CITY OF ALBUQUERQUE

January 6, 2010

Re: Walgreens at Ventura and Paseo del Norte, 8011 Ventura St NE
Permanent Certificate of Occupancy - Approved
Engineer's Stamp dated 4-21-08 (D20/D010)
Certification dated 10-14-09

Walgreens at Ventura and Paseo del Norte (D20/D010)

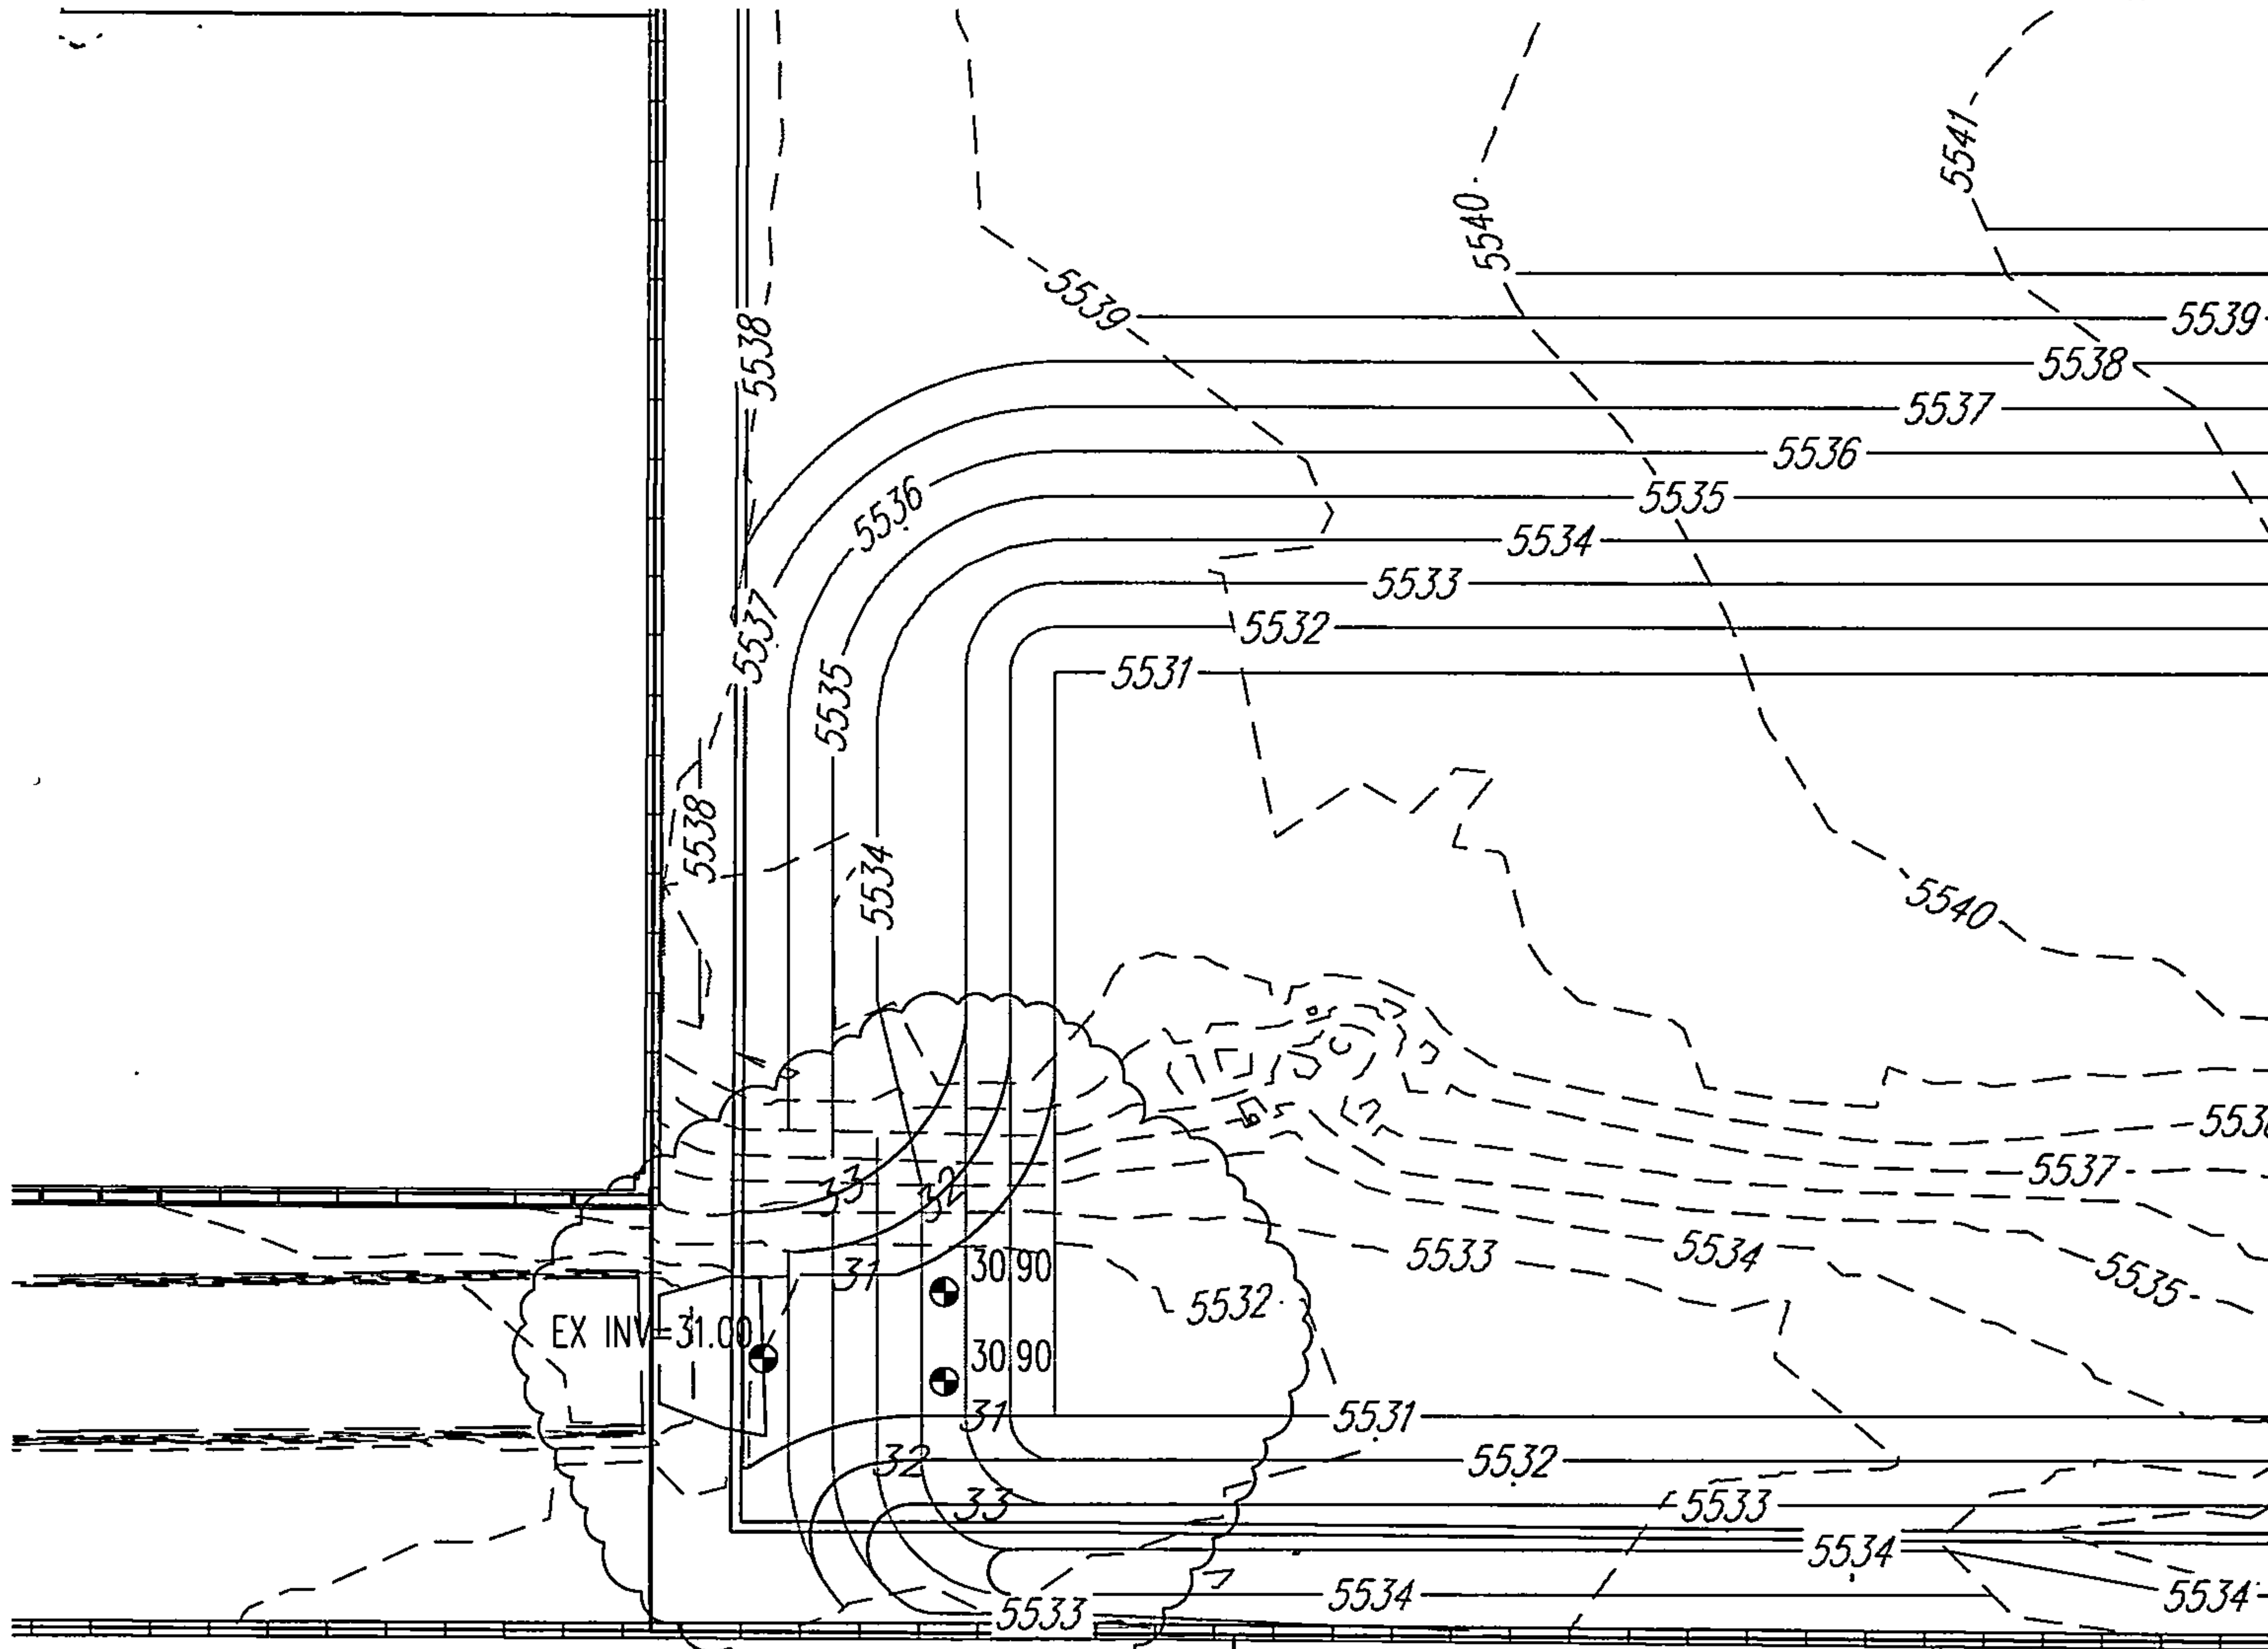
See AYM
Basin E probably 2 cfs
less the storm
